Re: TR El Paso Rezoning Application

This firm represents the Upper Black Squirrel Creek Ground Water Management District (the “District”), a formed and operating ground water management district with the powers enumerated in the Colorado Ground Water Management Act, C.R.S. § 37-90-101 *et seq.* The District has reviewed the application submitted by TR El Paso Land, LLC (c/o Greg Harington) (“Applicant”) to subdivide its 275.89 acre property and rezone the property from R-4 to A-35. According to the Application, water will be provided by individual site wells drilled into the Dawson aquifer and wastewater served through individual onsite wastewater treatment systems.

MORGAN'S MEADOW

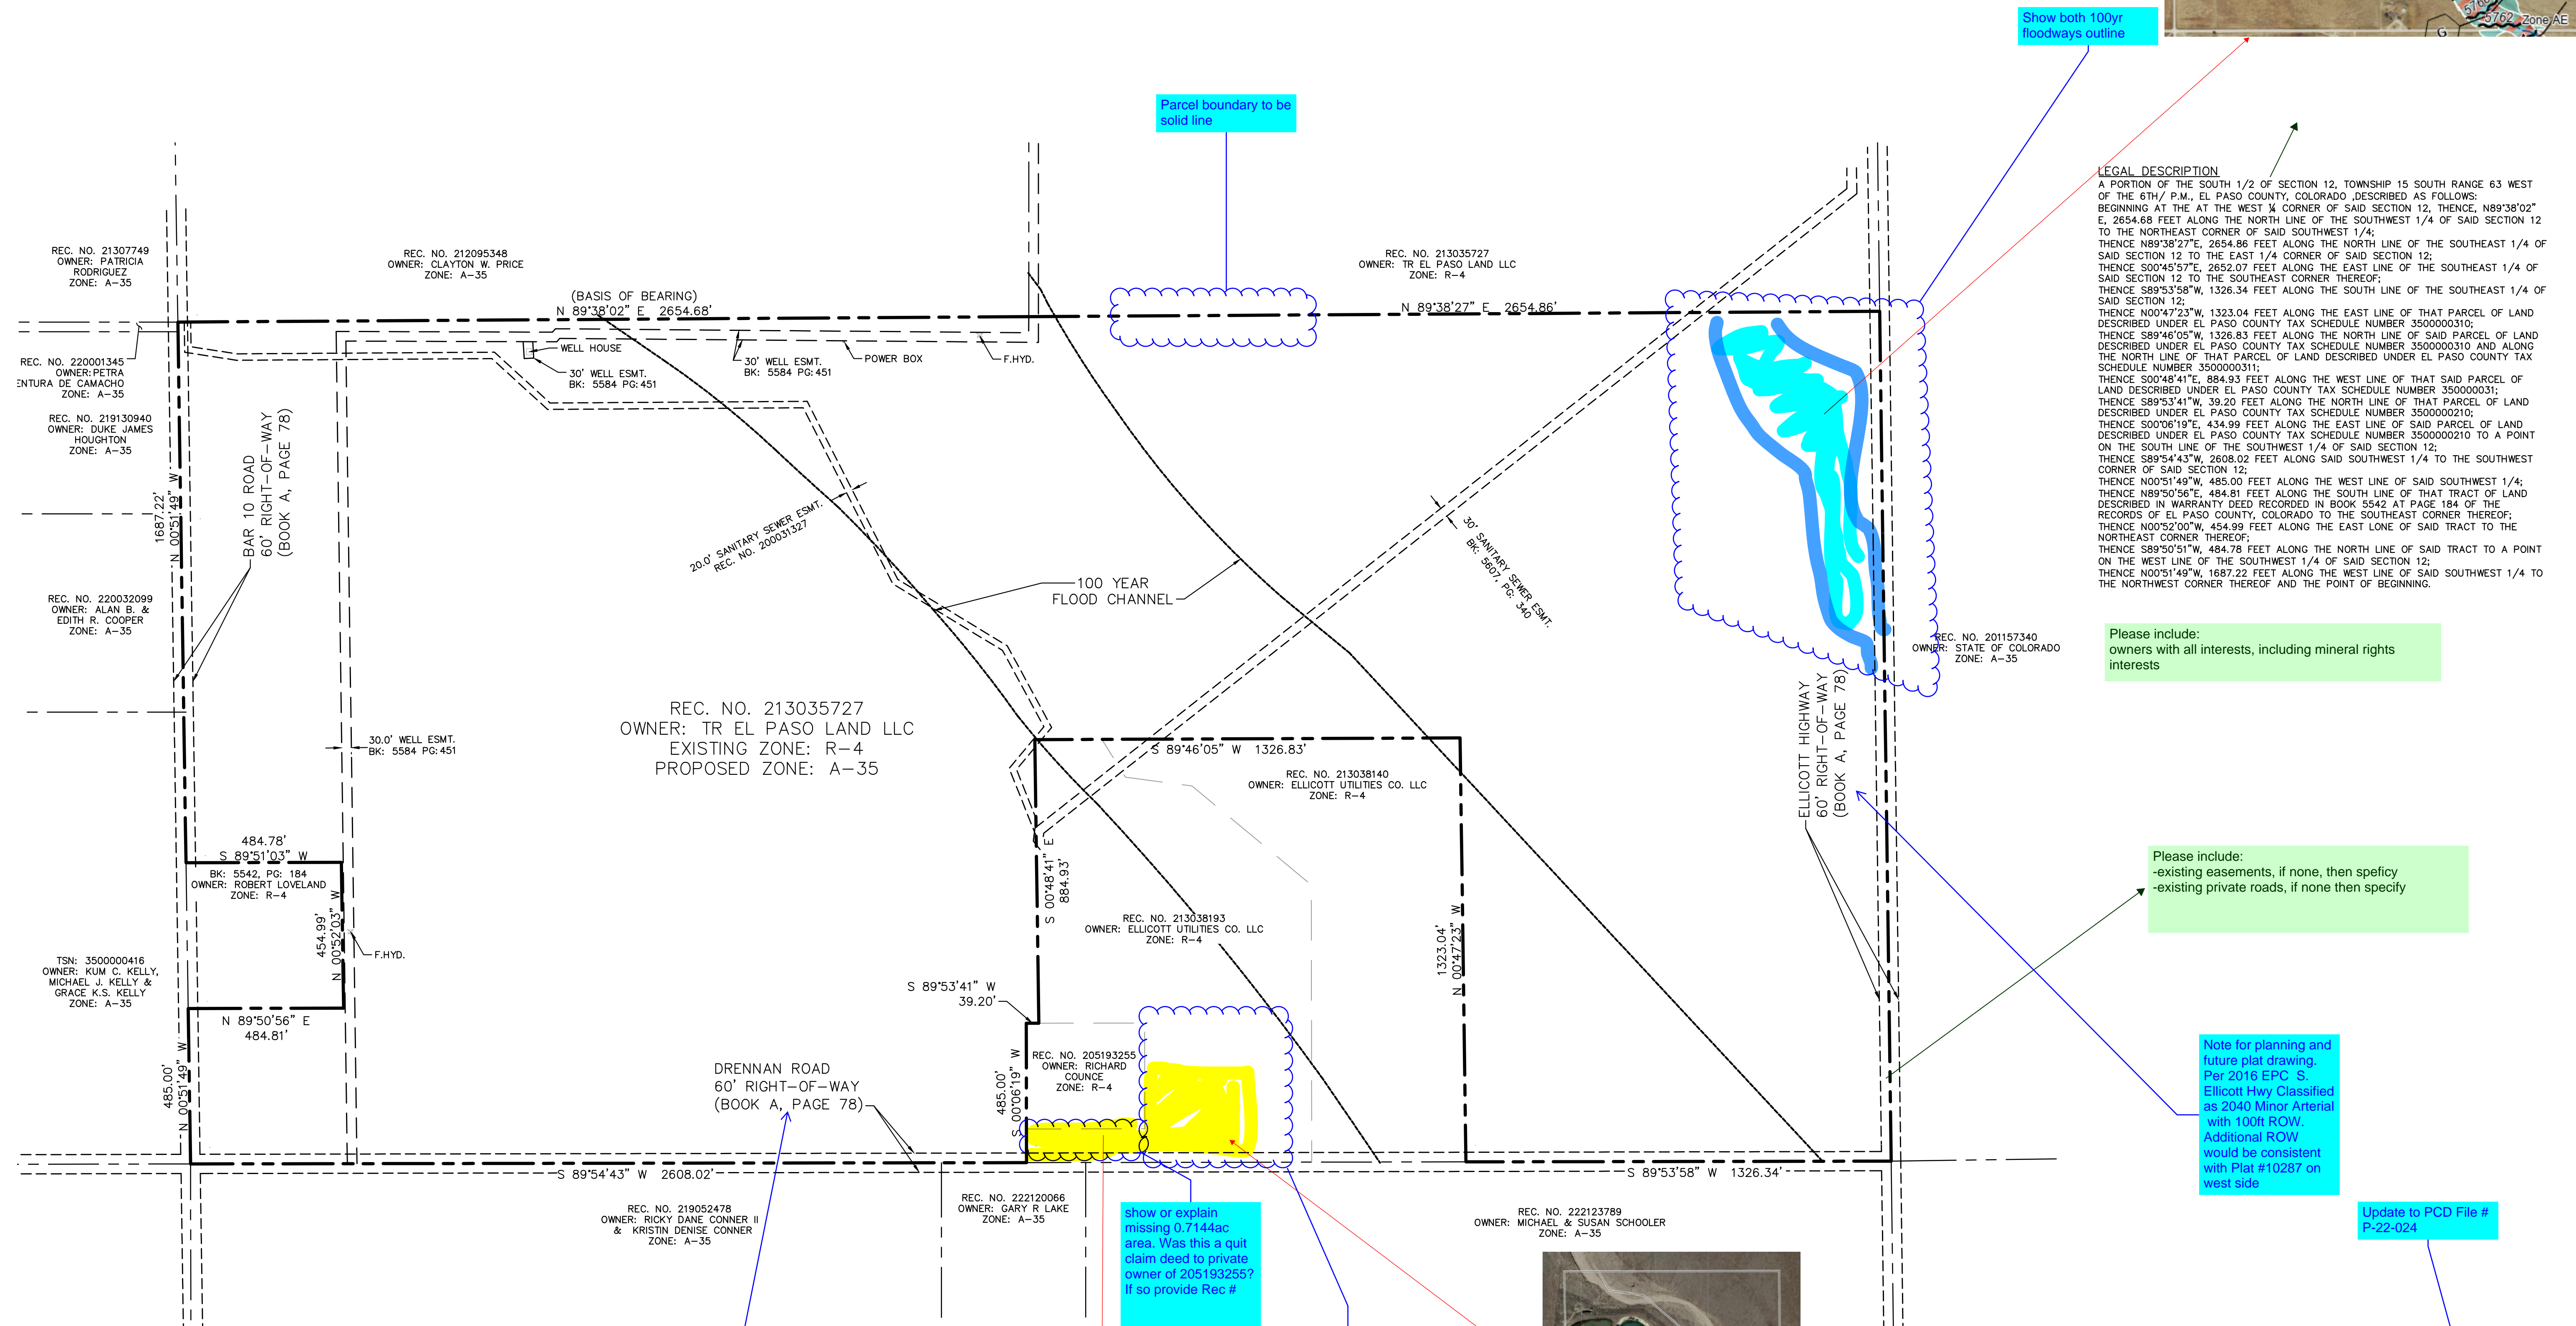
Applicant stated on the Type D Application Form (1-2C) Description of the request that Applicant proposes to subdivide the property into “six (6) 35 acre, minimum, lots.” However, the attached Letter of Intent states that Applicant requests “Approval to develop 7 lots under the A-35 zone.” The District would appreciate clarification as to the number of lots proposed under the application.
